HIGH PLAINS FILING NO. 1

PRELIMINARY PLAN

Markup Summary

## PRELIMINARY PLAN

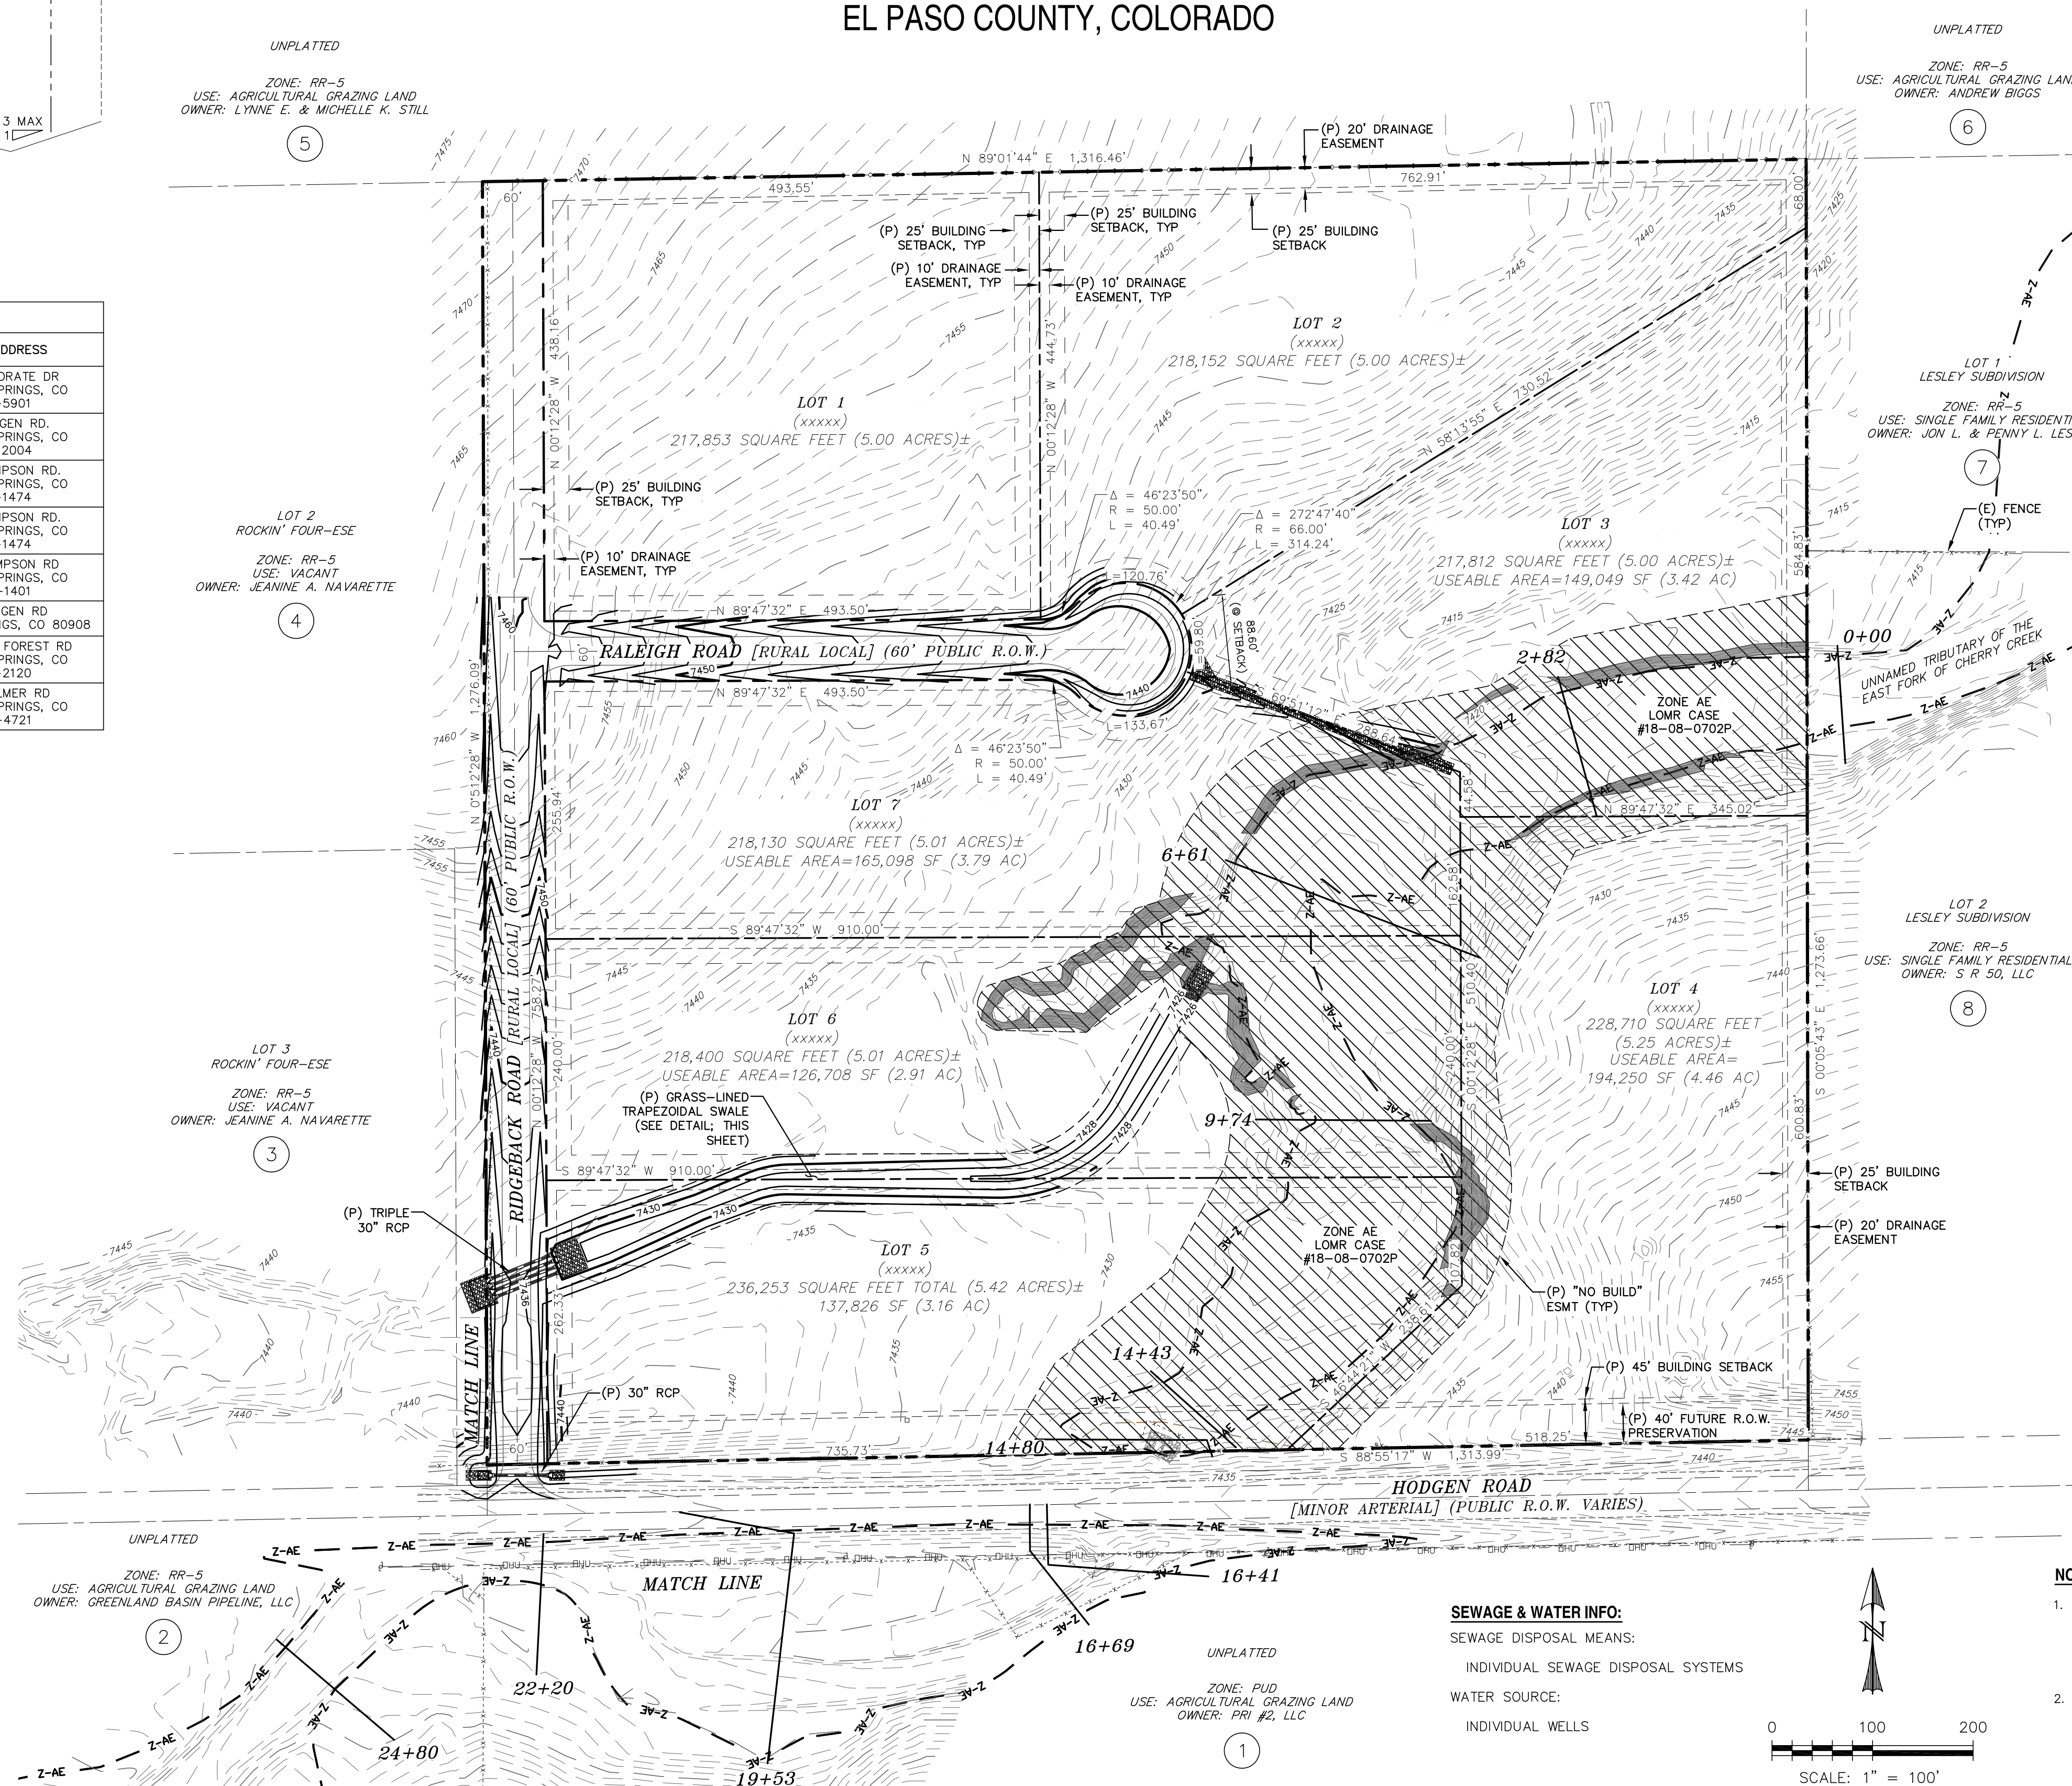
Indicate road classification and surface material

Move the street label so it's not blocking the street line work which shows the limits of the proposed road.

Provide a preliminary grading plan

Label whether these are existing or proposed culverts

Provide a preservation easement. Per the MTCP Corridor Preservation Plan, Hodgden is identified as a 4-lane arterial (180' ROW)

Clearly label FEMA 100yr floodplain and indicate that it is a no-build/no-storage area and/or add to legend

Indicate road classification and clearly show ROW dedication.

Any area with slope greater than 30% should be no build. Revise net acreage once no-build is shown (including floodplain).

The soils report identifies some potential hazards that can be mitigated. Please either show these areas as no build or add a note indicating the mitigation method.

Please indicate how gas, electric, fire, water and sanitation will be provided.

Provide a typical road section for proposed roads

add setback line for when lot width is met.

add bearing
